Subject: K/3/14 69 Coastal Road

Objections to revised plans:

REVISION			
PROJECT		Proposed Development at 69 Coastal Road, East Preston	
SUBJECT		Plot 2 - Floor Plans and Elevations	
SCALE 1:100	DATE April 2012	DRAWING No 11 / 46 / 02	Rev D
DRAWN	CHECKED

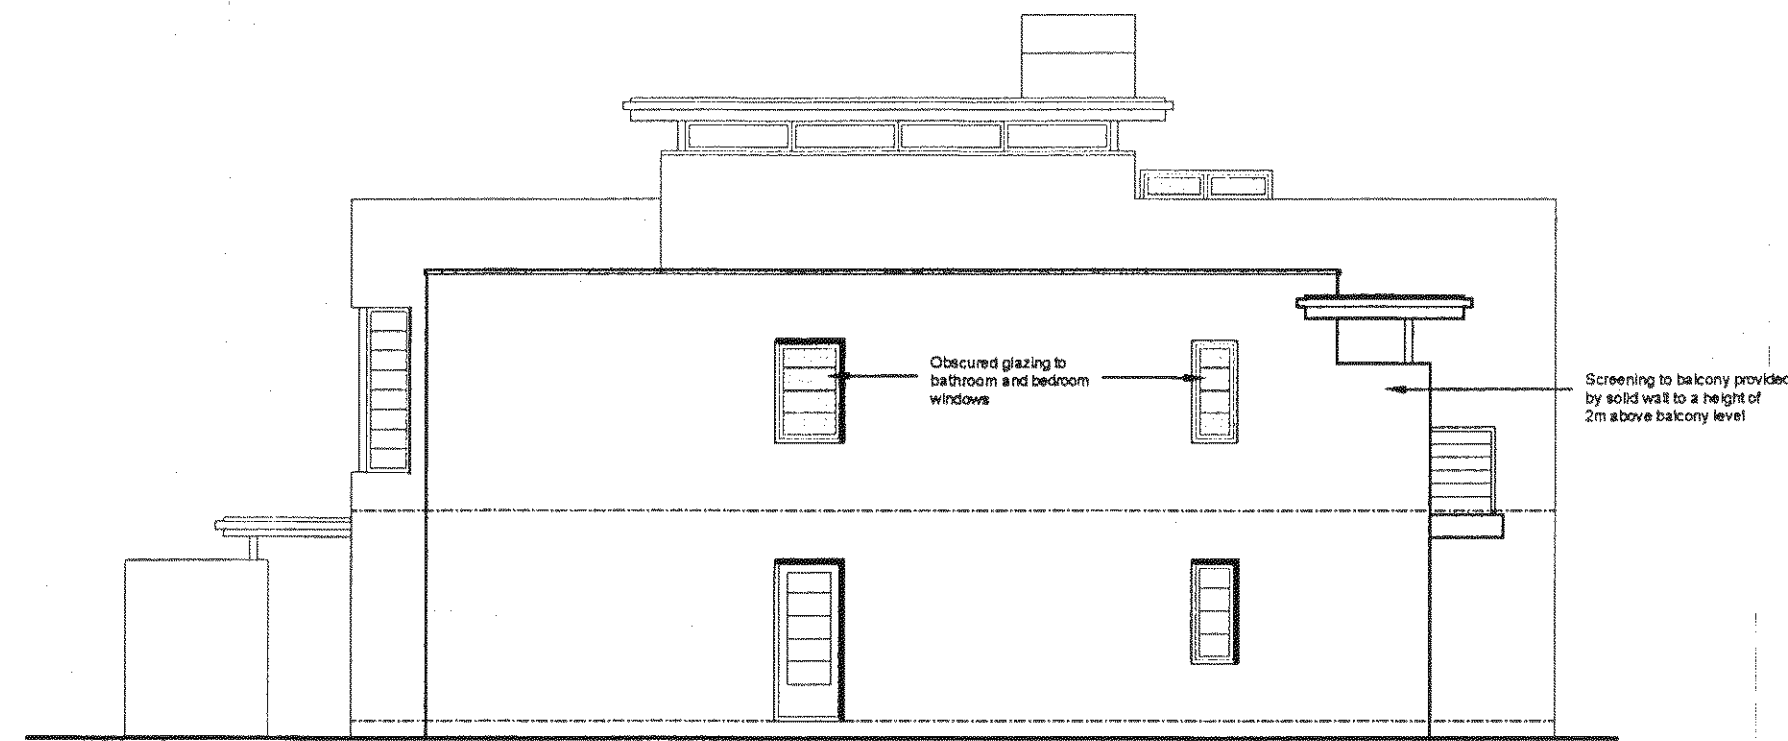
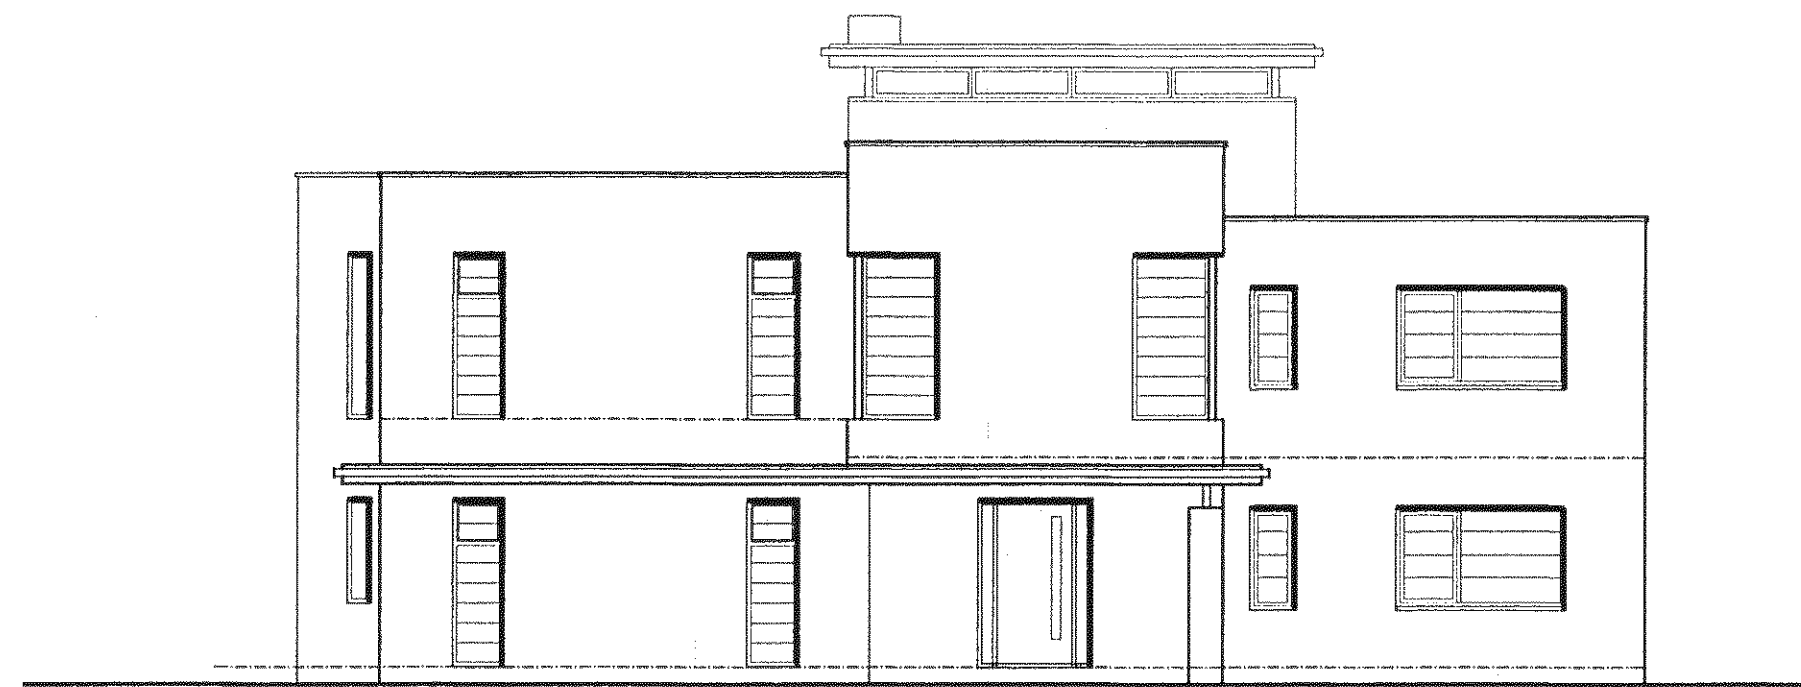
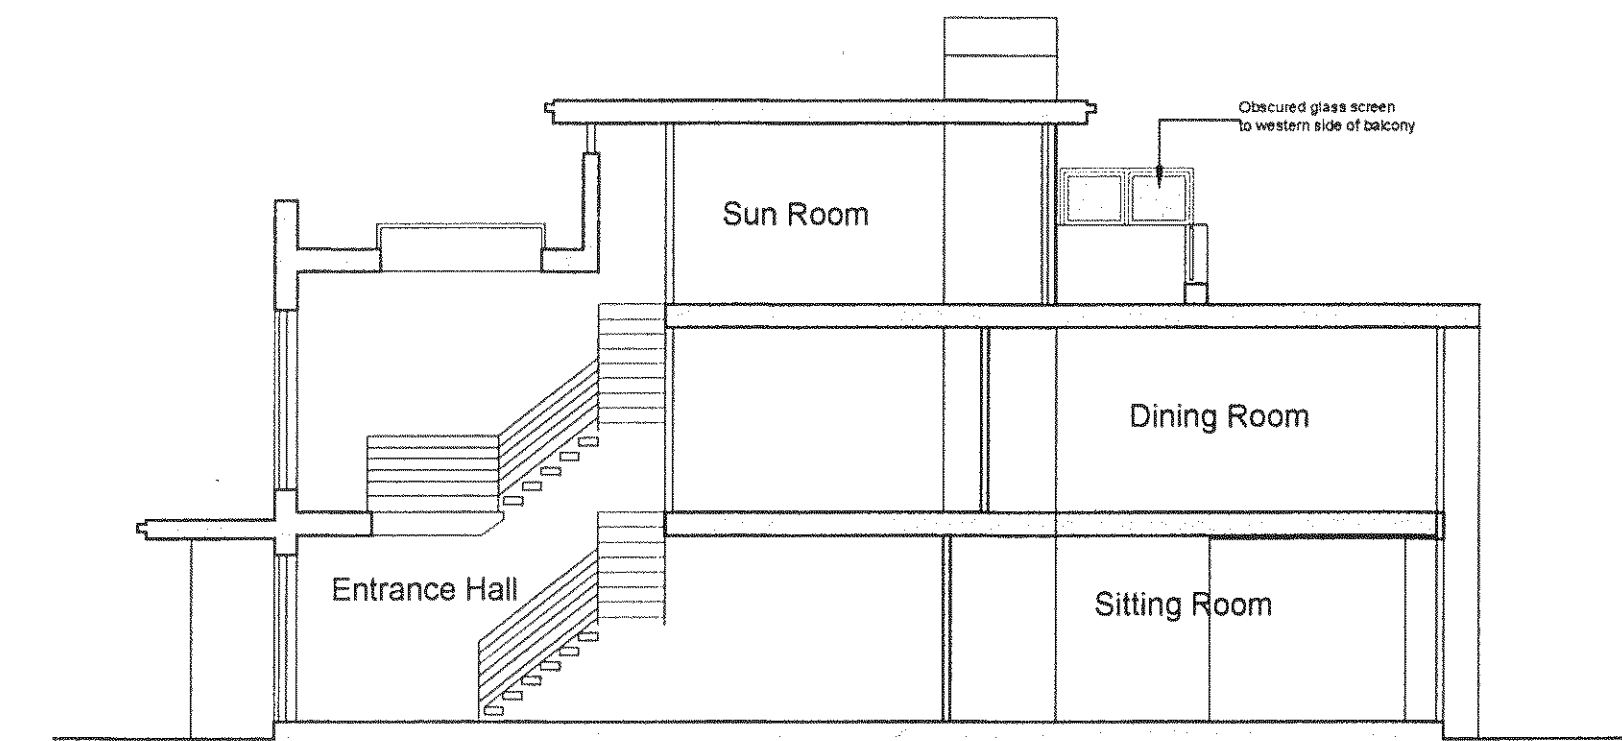
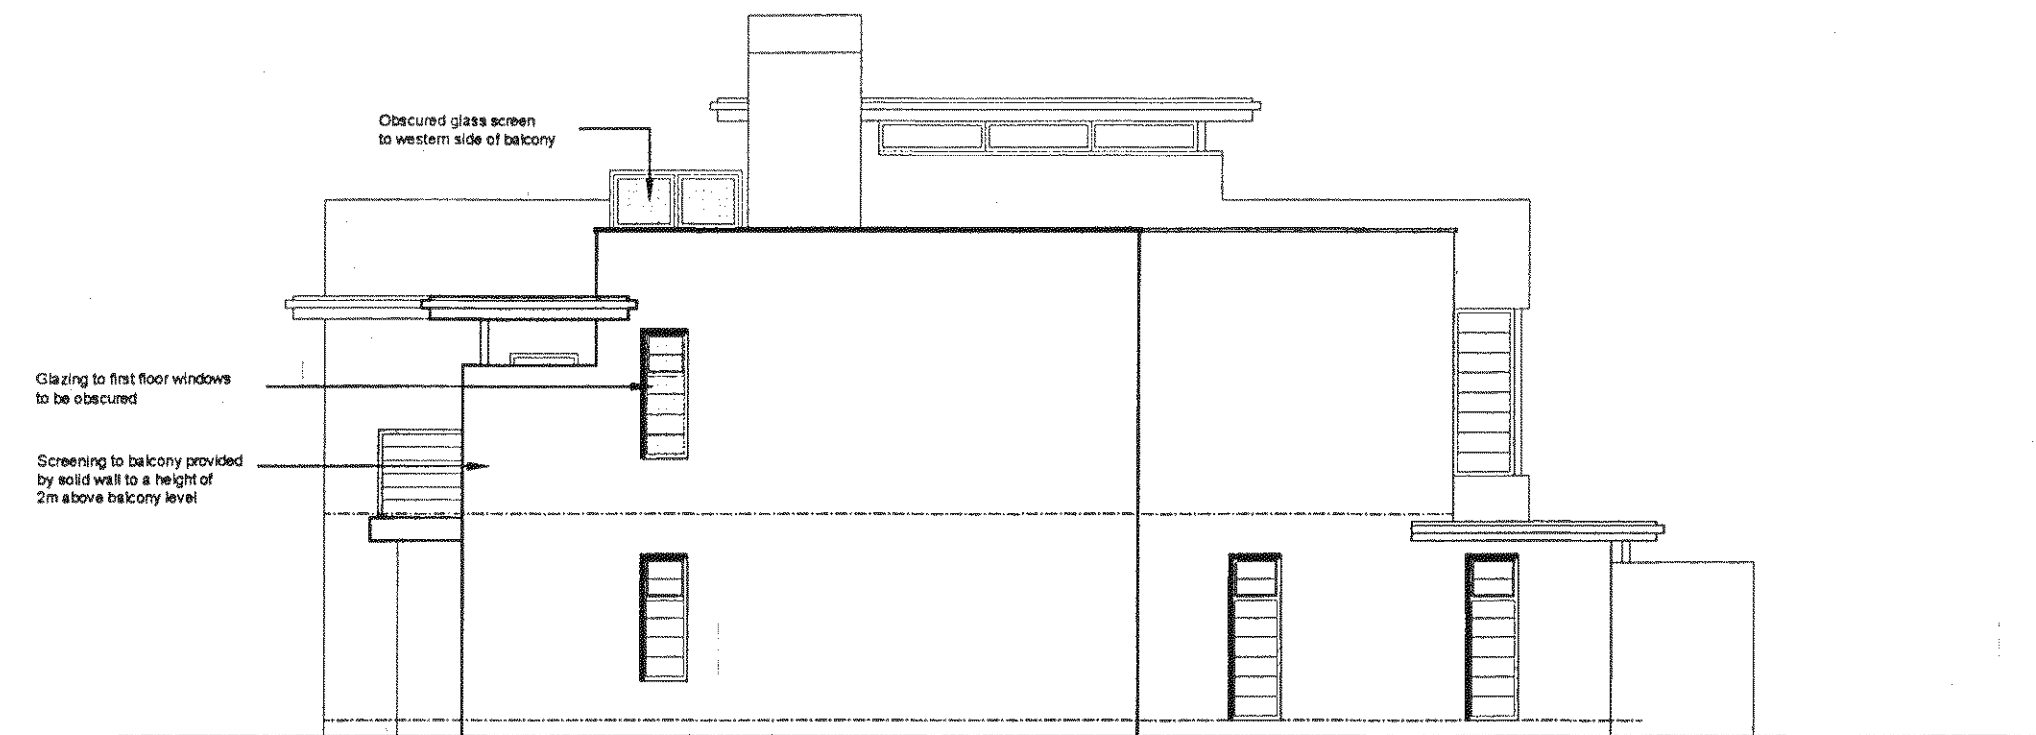
Third storey sunroom : we have objected to a third storey on this plot on each occasion that planning consent has been sought. A sunroom in such a location is obviously unnecessary and an enablement for rooftop amusements which also blocks sunset light from the surrounding houses.

| REVISION |            |                                                           |     |
|----------|------------|-----------------------------------------------------------|-----|
| SUBJECT  |            | Proposed Site Plan                                        |     |

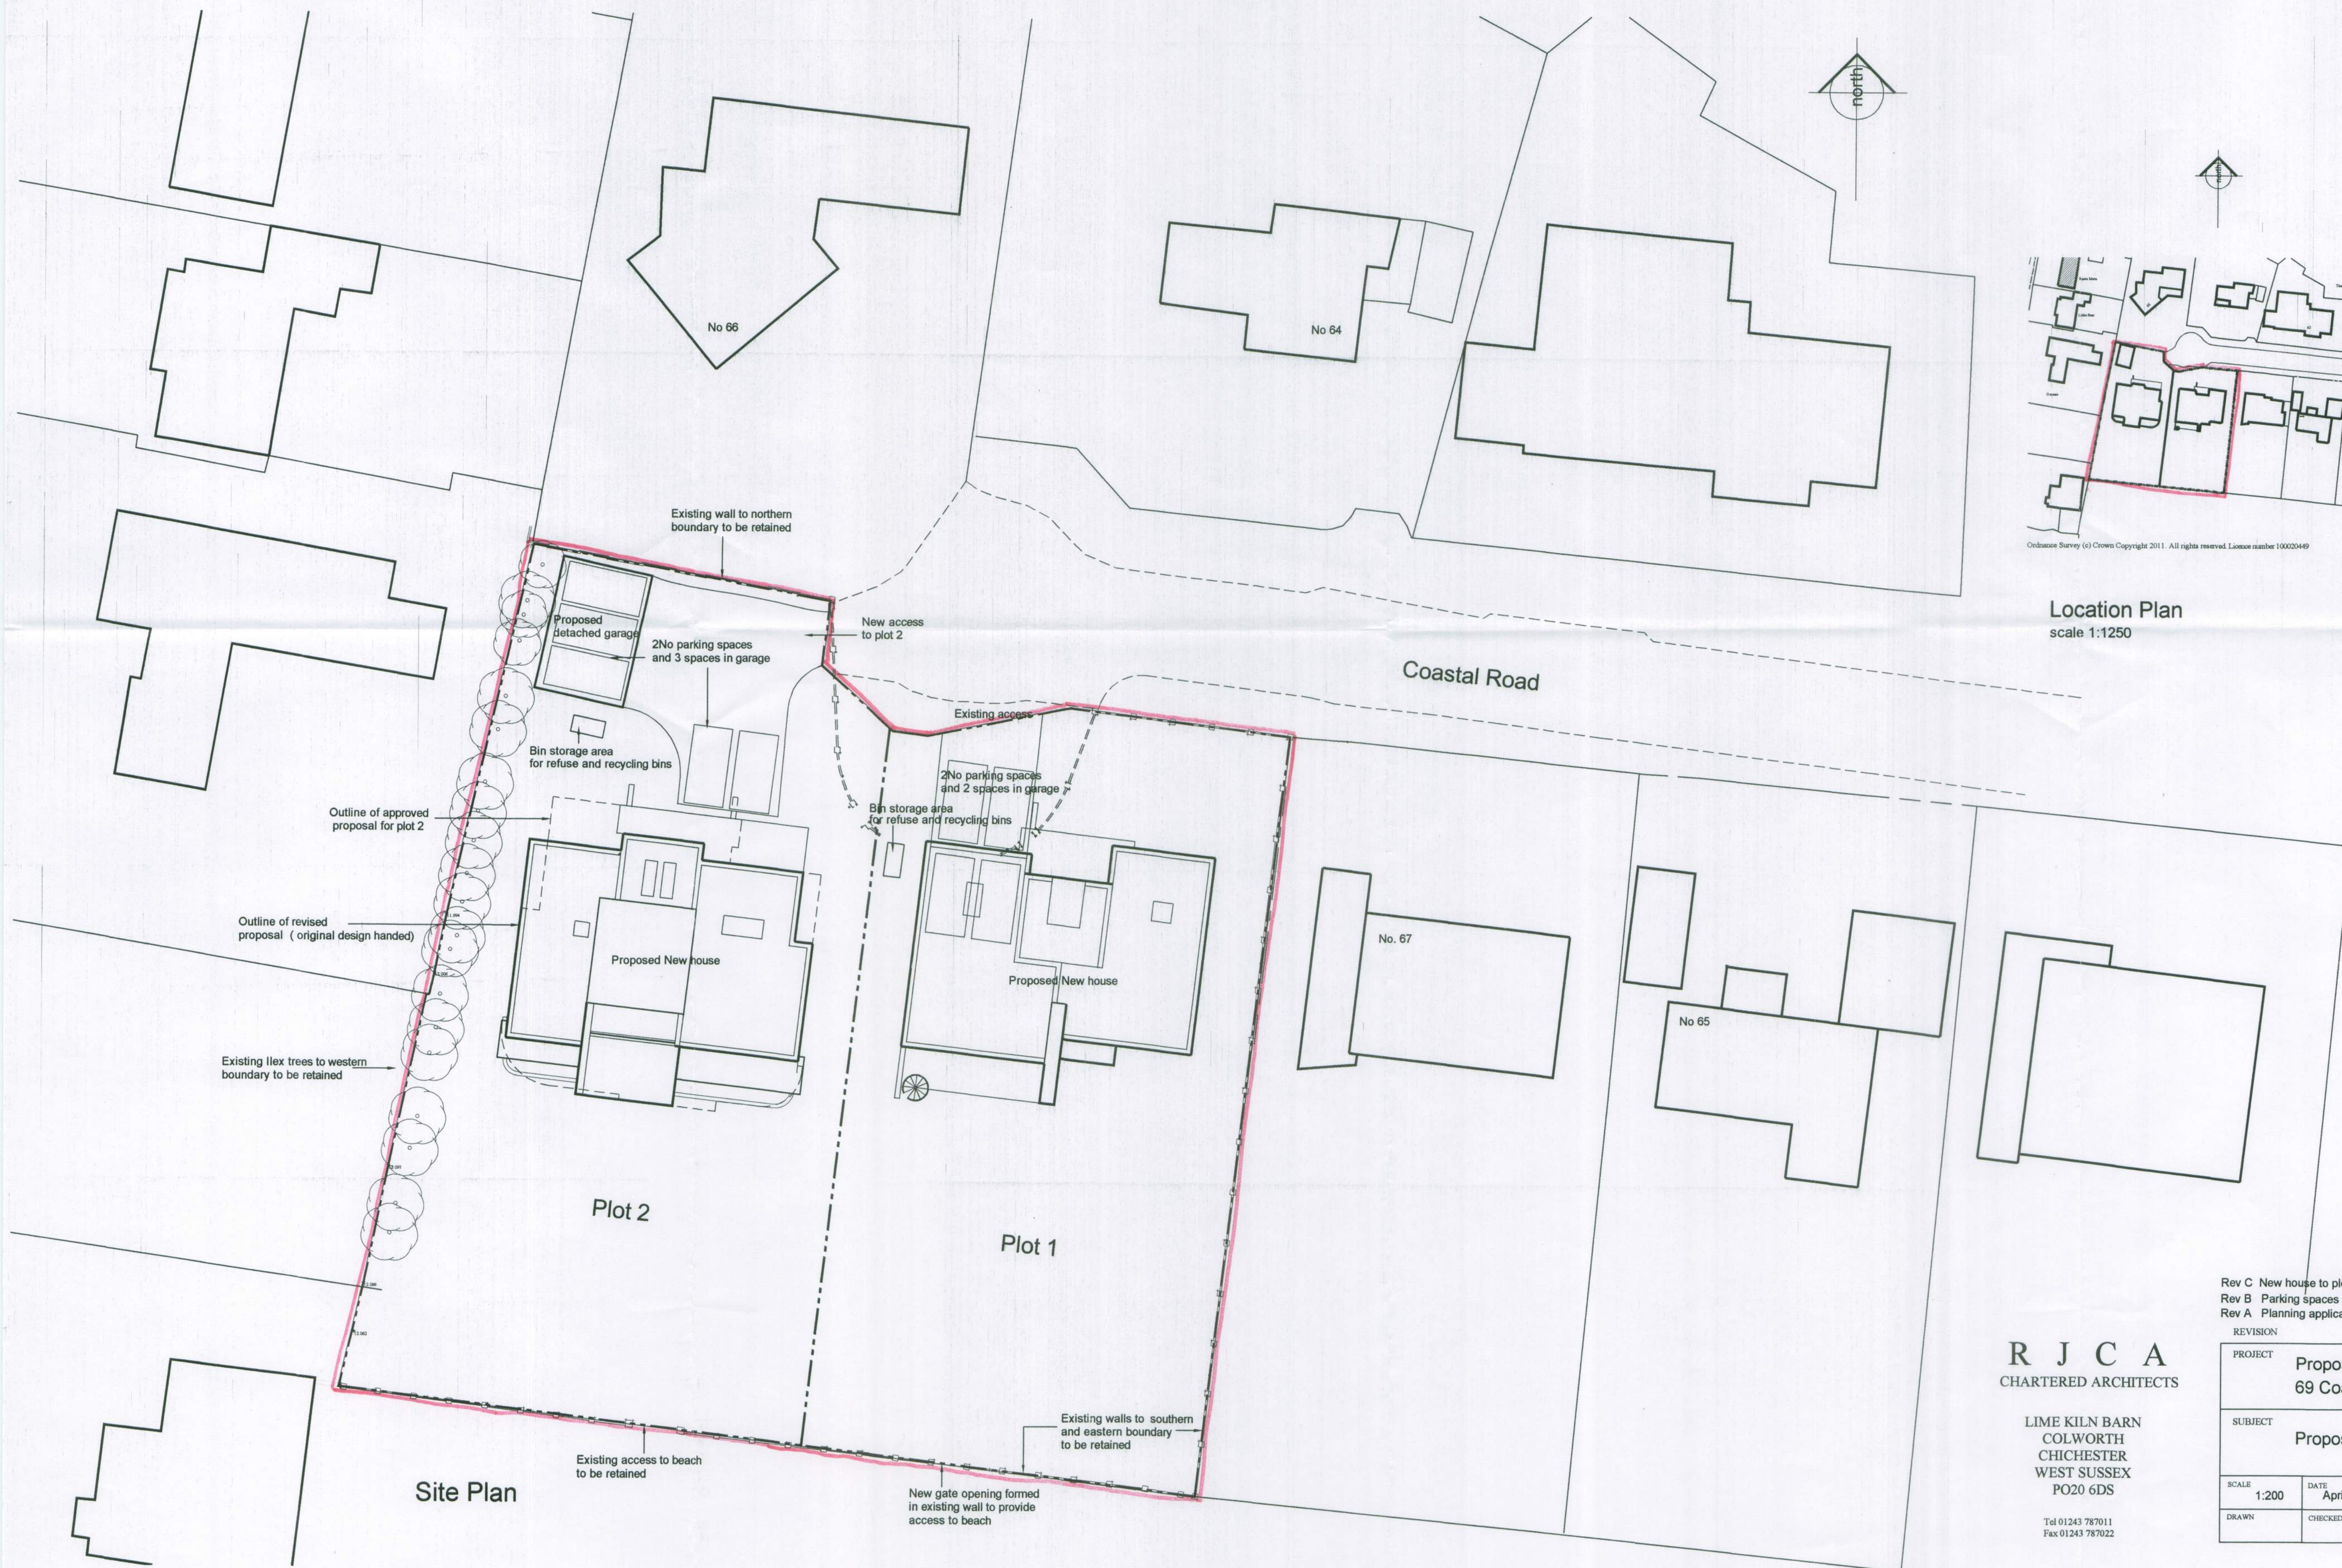
Separate one-storey triple garage facing east: an unsightly addition to depress the street scene at the end of this cul-de-sac where most garages are integral; (If such a building is permitted it should face south ie towards the new-build rather than towards the road)
